Subject: Shoreline Exemption Permit (SX-22-00018 Lauckhart) – Deemed Incomplete – Request for Additional Information

LAUCKHART DECK REP.
232 MOUNTAIN VIEW LANE
EASTON WA, 98825

SITE PLAN

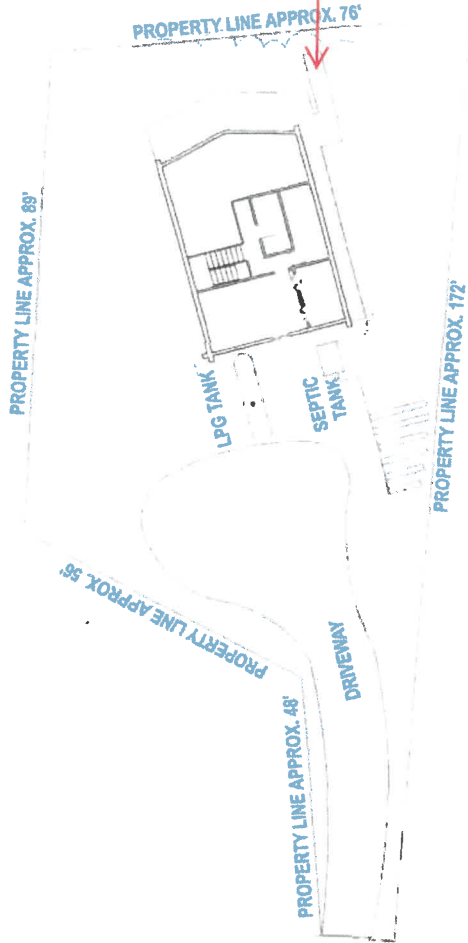
1. Please provide clarification on what appears to be an addition to the existing structure. The area of concern has been identified on the attached documents.

Does not appear in
previously provided
building permit site
plans or on
Assessor's sketch.
Please provide
clarification.

Sketch by Apex Sketch

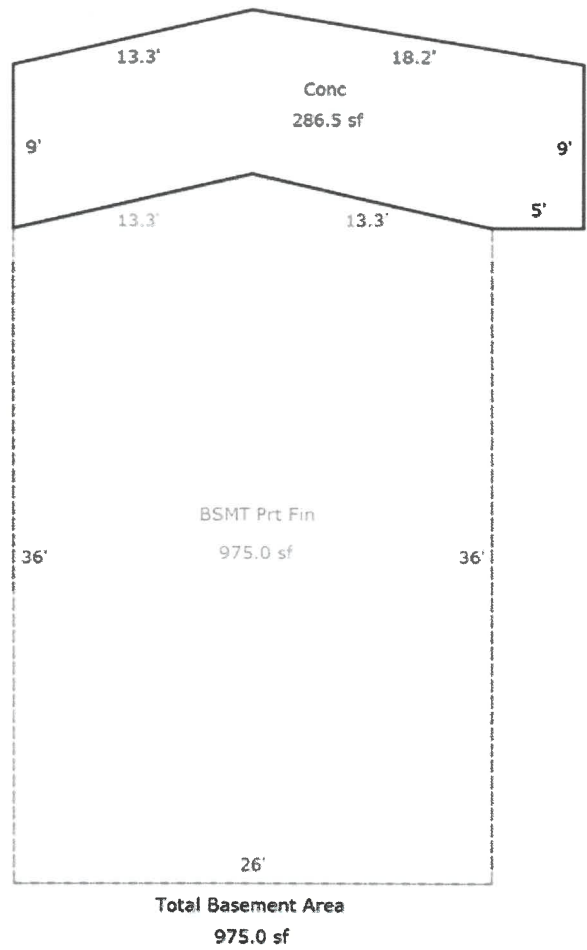
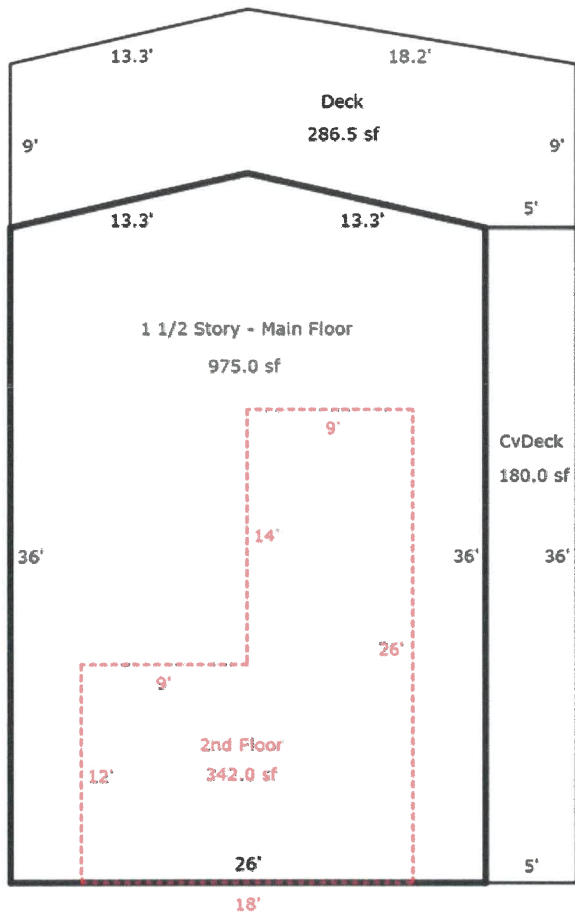
I have attached a copy of your submitted site plan with the area of concern identified. Additionally, I have provided a copy of the Assessor's sketch and a copy of a site plan from a 2019 building permit (BP-19-00850), both of which do not show the area of concern as is seen in your recently submitted site plan.
